Permitting and Inspections Department
Michael A. Russell, MS, Director

CBL: 065 B007001
Located at: 6 HEMLOCK ST

Inspection Violations

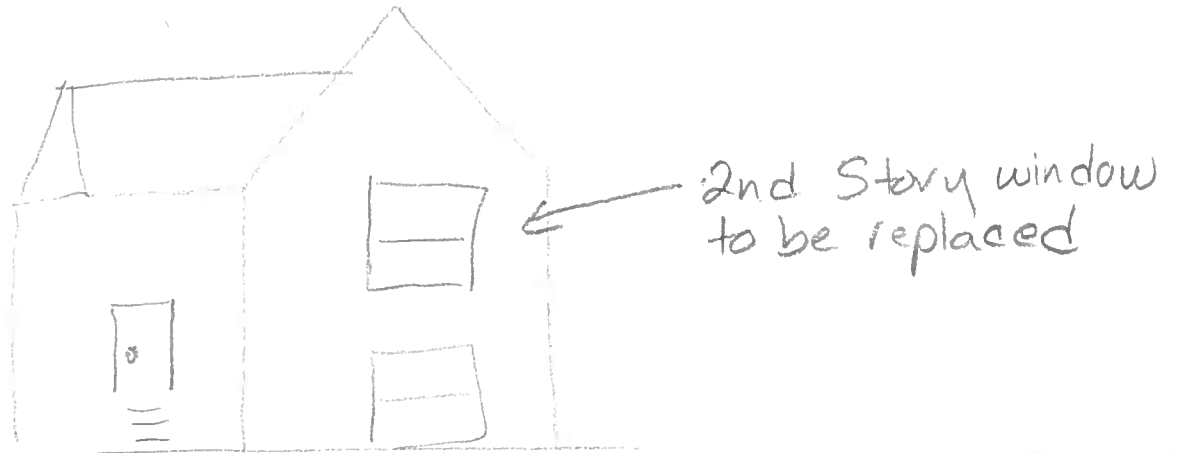
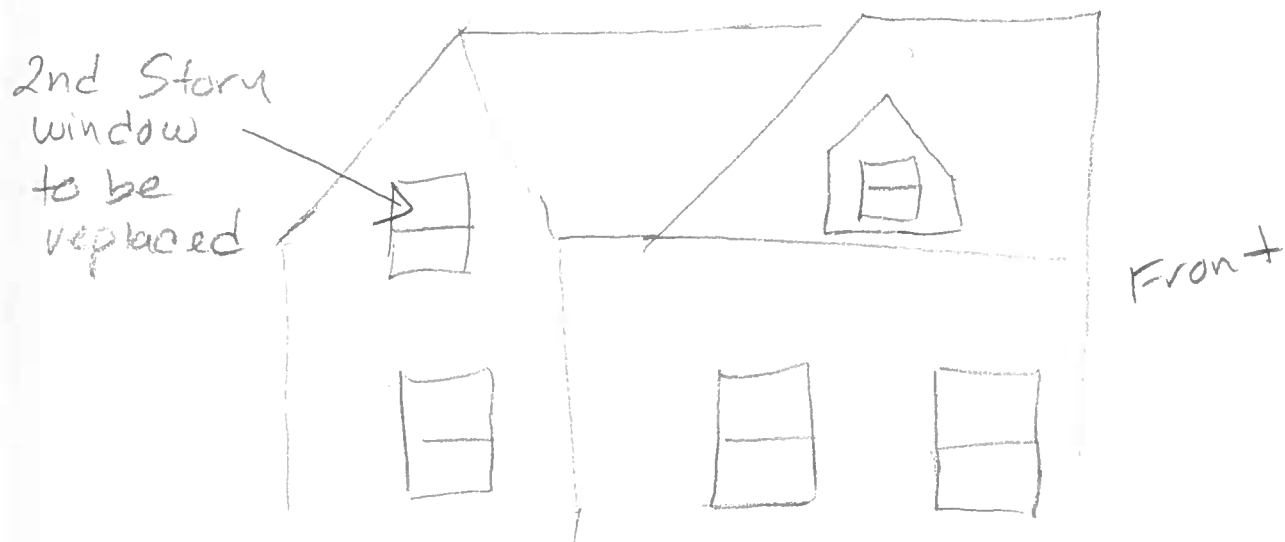
Comments: 11/29 Inspection. Field Inspection- Upstairs bedrooms do not meet egress window requirements. The windows are too small in size. One bedroom's window measured to be 17 inches high by 15 inches wide. Two other bedrooms had windows measuring 29 inches high by 18 inches wide.

Notes: The normal operation opening of the window shall be at least 20 inches wide by 24 inches high (3.3 square ft.). The entire window frame opening shall be at least 5.0 square feet. If rough opening of a window needs to be changed than the window must meet the NFPA code requirements of 5.7 square feet.
